Re: Burger King
7101 Lomas Blvd. NE
Traffic Circulation Layout
Architect's Stamp 01-31-23 (J19-D052)

Based upon the information provided in your submittal received 05-01-23, the above referenced plan cannot be approved for Building Permit until the following comments are addressed:

G RAMP STANDARDS

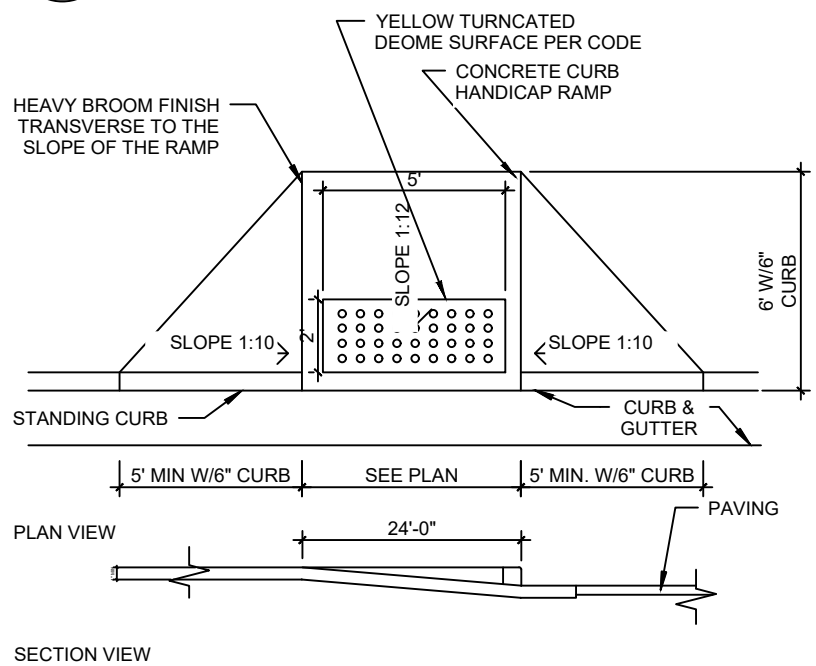
1. Identify all existing access easements and rights of way width dimensions.
2. Please provide dimensions for the existing parking spaces at the north side of the site.
3. ADA curb ramps at both site accesses must be updated to current standards and have truncated domes installed.
4. Keynote 4 & 26: Please define ADA pathway from the public sidewalk to the building entrance by labeling flush, or ramps, and provide the width.
5. Site access off Louisiana: A minimum 4-foot wide pedestrian pathway should be shown around each existing pole. Please show this dimension on the site plan to ensure that a minimum 4-foot wide path is obtained.

DO NOT ENTER SIGN

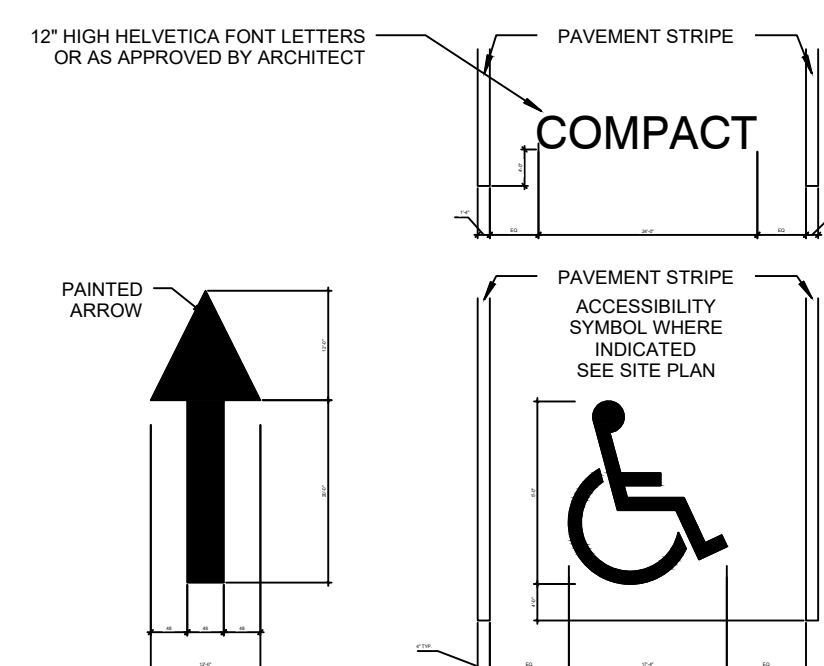
6. Please provide "ONE WAY" and "DO NOT ENTER" signage at the beginning and the exist of the drive-thru lane.
7. 12 ft. is the minimum drive-thru lane width. Please revised the site plan.
